**Consultation Response from KC,  
Lead Local Flood Authority**

**2022/93516 adj, 71, Southern Road, Cowlersley, Huddersfield, HD4 5TJ**

**Erection of one dwelling with detached garage**

**Date Responded: 30<sup>th</sup> November 2022**

Proposed Site Section 1
 1 : 100

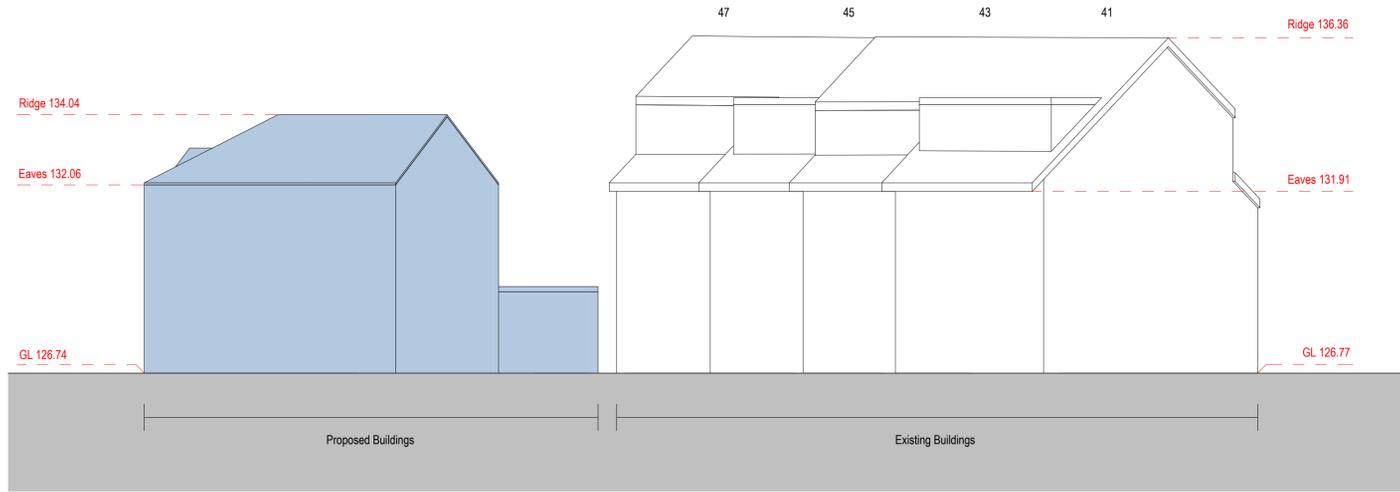
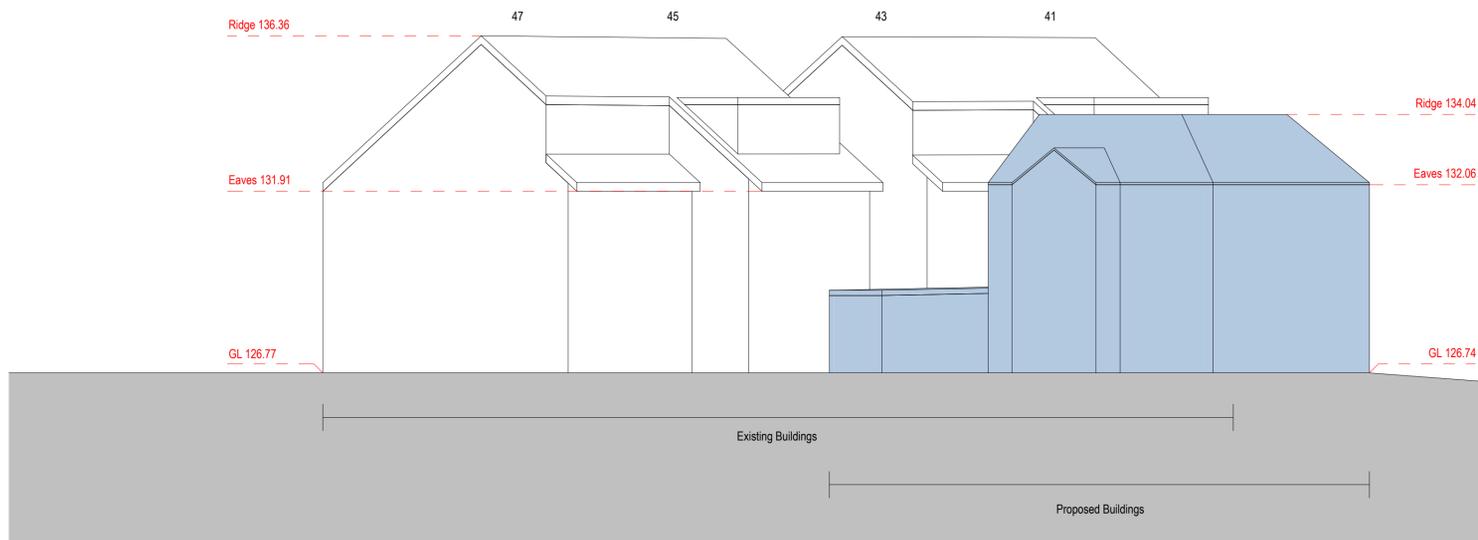
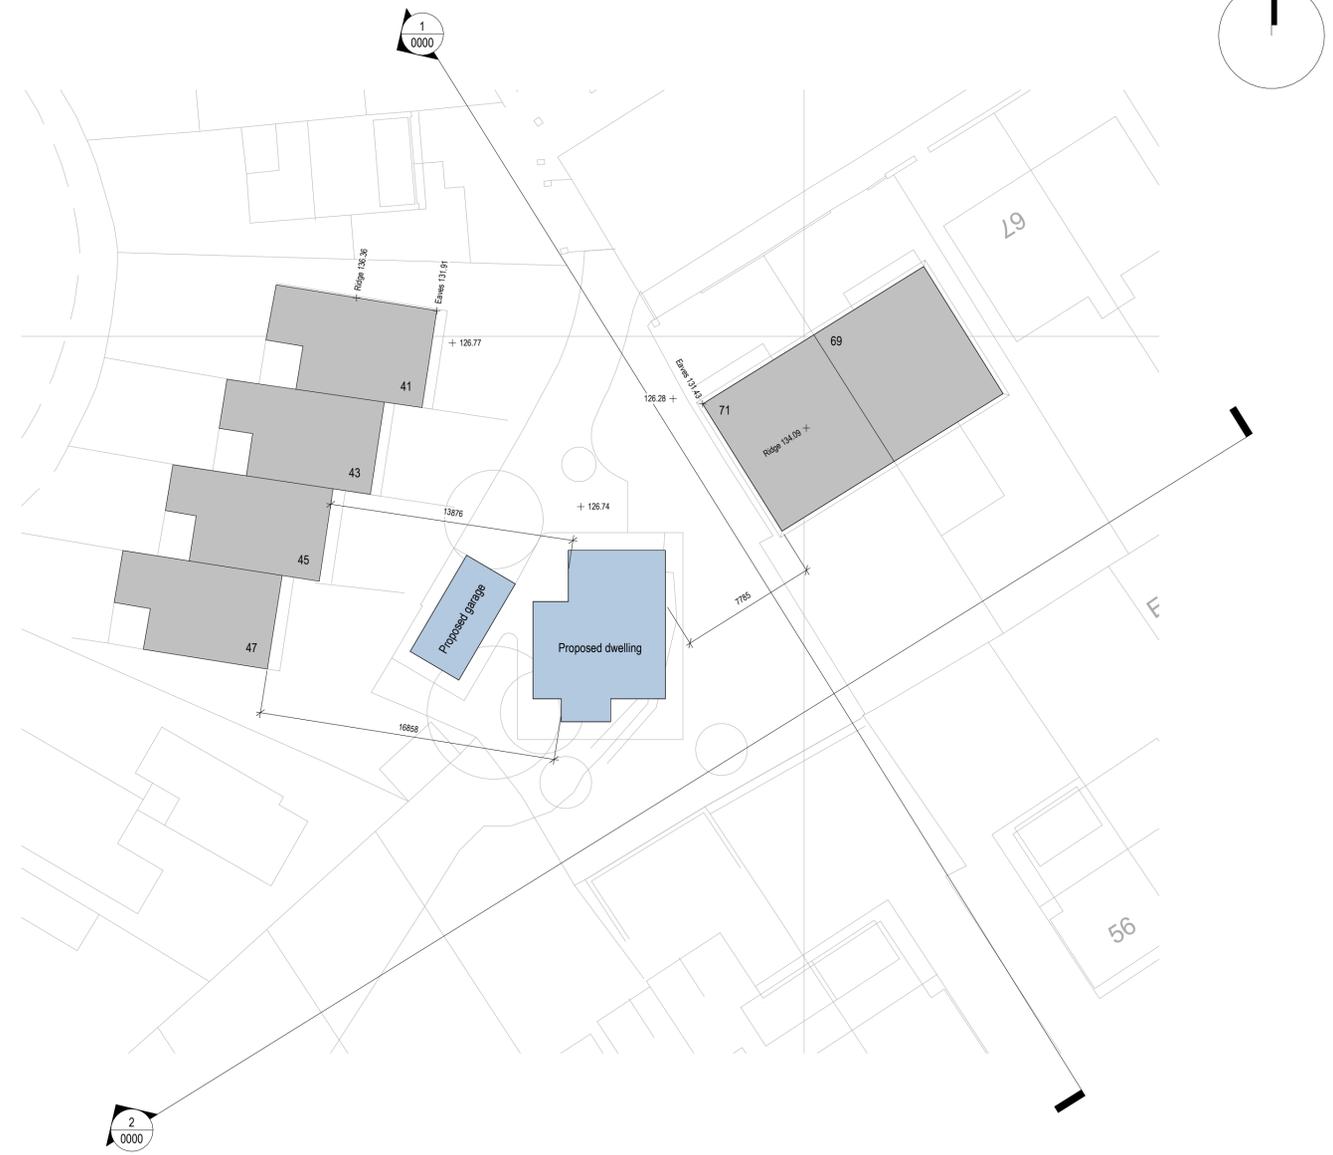
Finished floor levels and surrounding ground levels must allow for a blocked watercourse scenario where overland flow will not form a basin of water around the property, but flow away from and therefore protect proposed and existing properties, and into Southern Road.

Levels must be taken on the watercourse, both open and enclosed within the site and beyond, with a CCTV of the downstream condition for at least 30 metres (or downstream manhole covers at lower level than the site (to be decided between applicant and LLFA)).

Third generation surface water flood risk maps show potential for overland flow across the area proposed for building. The LLFA will consider an engineered solution that prevent the property from being in a basin and encourages an overland flow route avoiding the property altogether and escaping onto Southern Road. This assessment must take into account levels of the properties 41-47 Warneford Road and their rear gardens as they have experienced flooding from this watercourse before according to LLFA records.
